<b>Location of Construction:</b> 915 FOREST AVE	<b>Owner Name:</b> BJFC LCC	<b>Owner Address:</b> 915 FOREST AVE	<b>Phone:</b>
<b>Business Name:</b>	<b>Contractor Name:</b> Benchmark	<b>Contractor Address:</b> 34 Thomas Dr. Westbrook	<b>Phone</b> 2075917600
<b>Lessee/Buyer's Name</b>	<b>Phone:</b>	<b>Permit Type:</b> Foundation Only/Commercial	<b>Zone:</b>

**Dept:** Zoning      **Status:** Approved with Conditions      **Reviewer:** Marge Schmuckal      **Approval Date:** 02/27/2007

**Dept:** Building      **Status:** Approved with Conditions      **Reviewer:** Mike Nugent      **Approval Date:** 03/23/2007

**Legend anchor bolt plan**

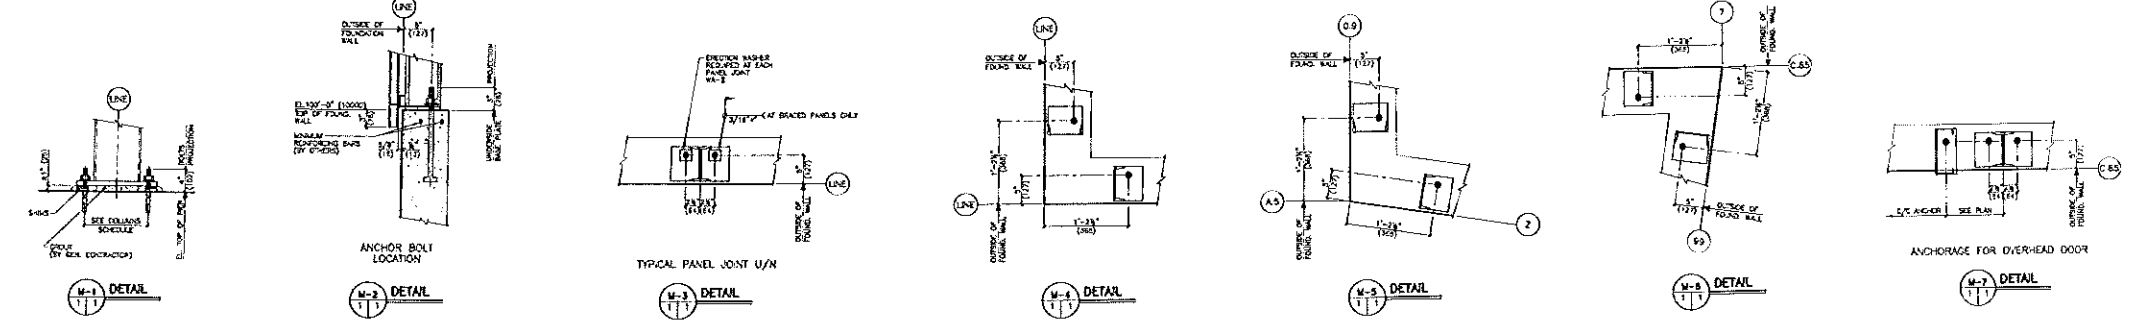
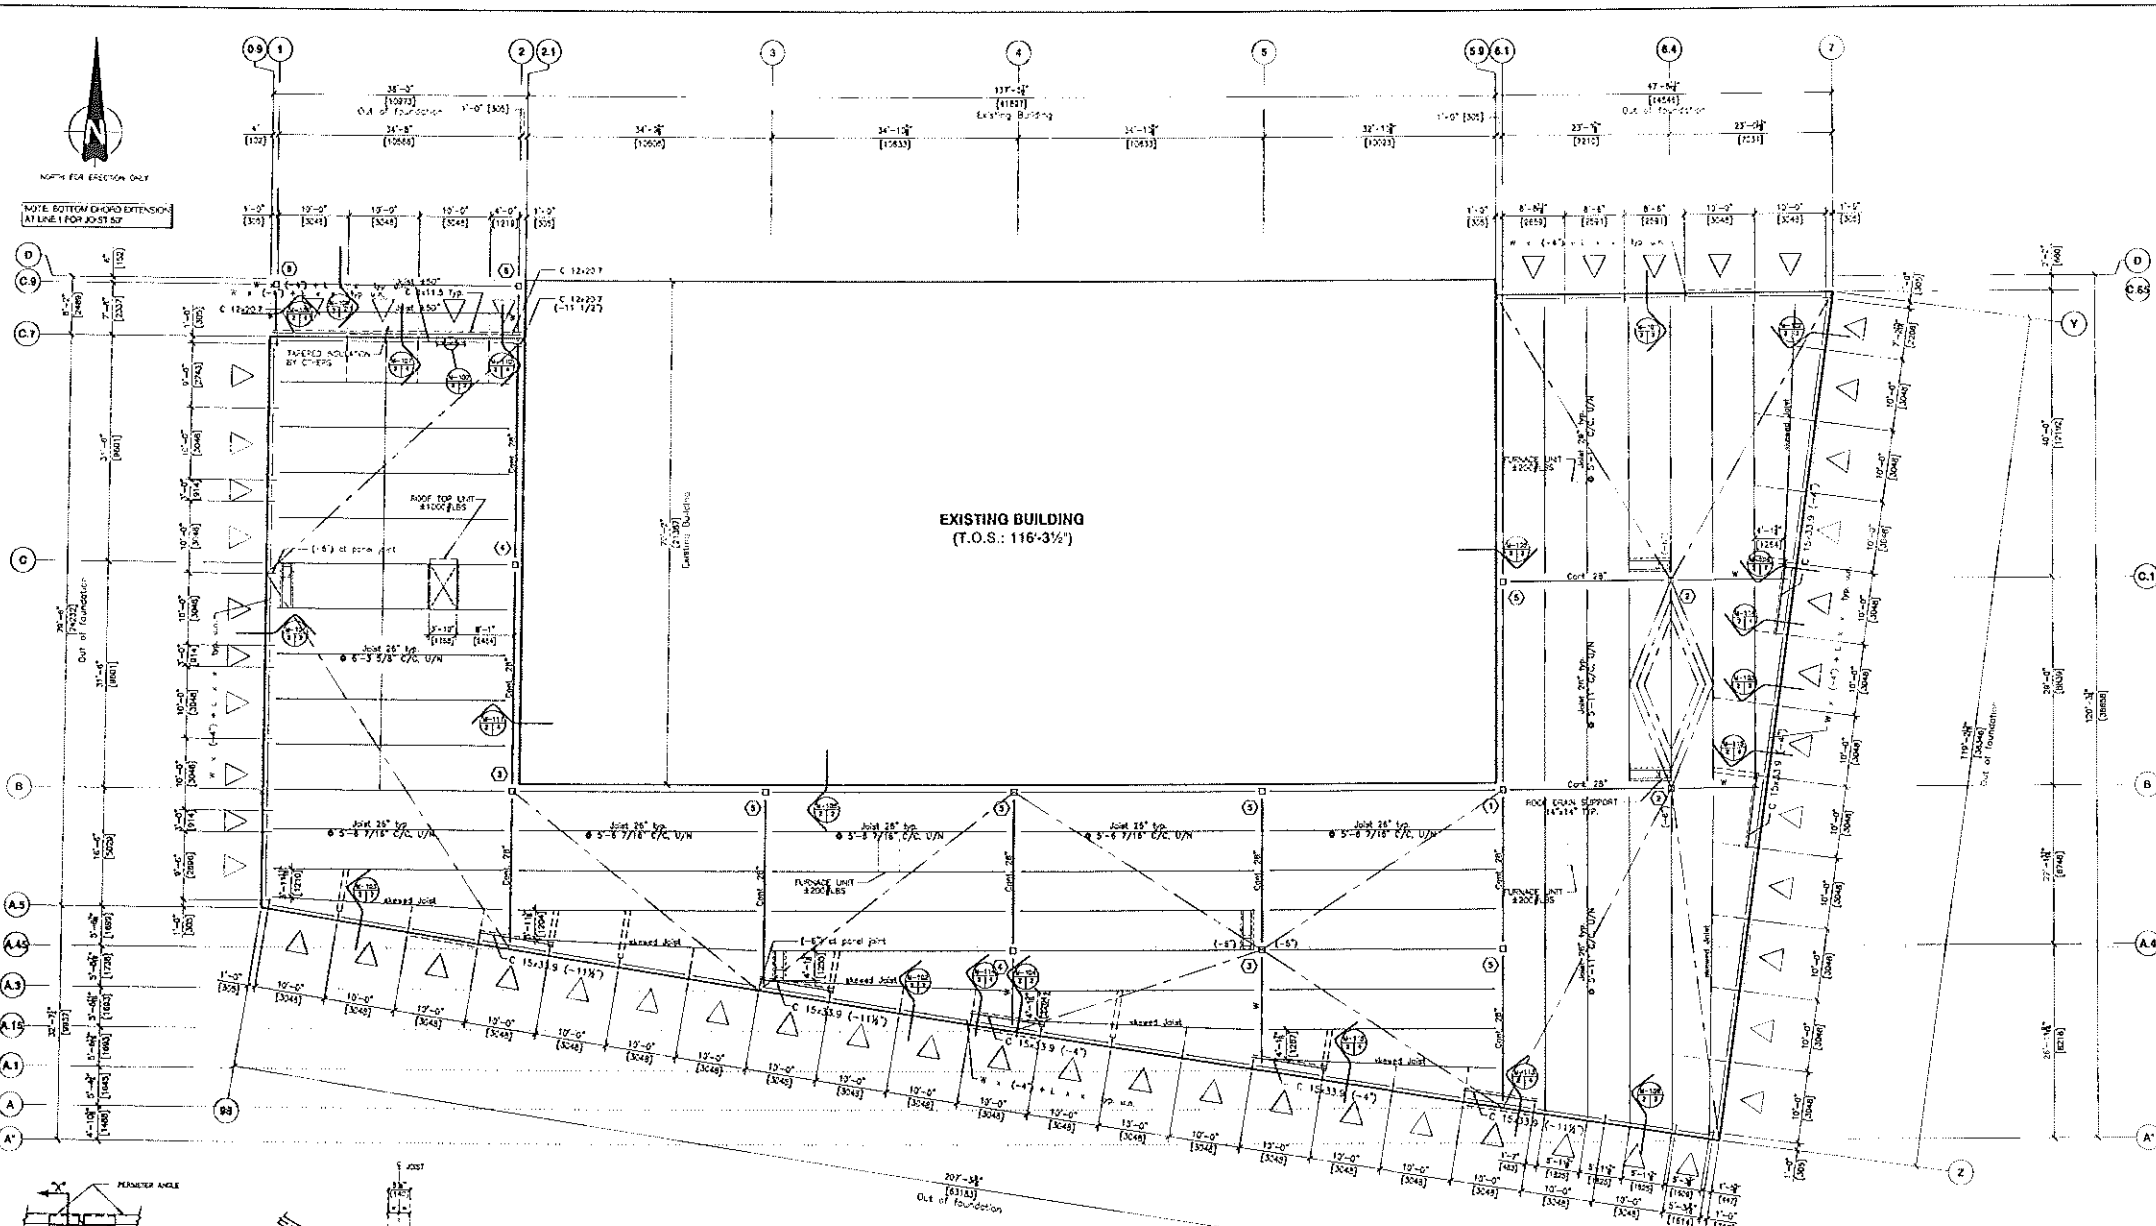
- 1) 1) The building must be at least 10 feet from the side and rear lot lines. This must be verified by the surveyor after the forms are set but prior to pouring the footings. This is to insure that the exterior walls will not have to be fire rated.
- 2) 2A)The anchors bolts must be included in the special insepction program. This was indicated as an "N" on the statement and is required. Please submit an amended report prio to setting the anchor bolts.
- 3) 2) The (or a) geotechnical engineer must be included in the special inspection program as indicated on page S0 of the submission (please include this on the Statement of S/I. Also the Owner's signature!
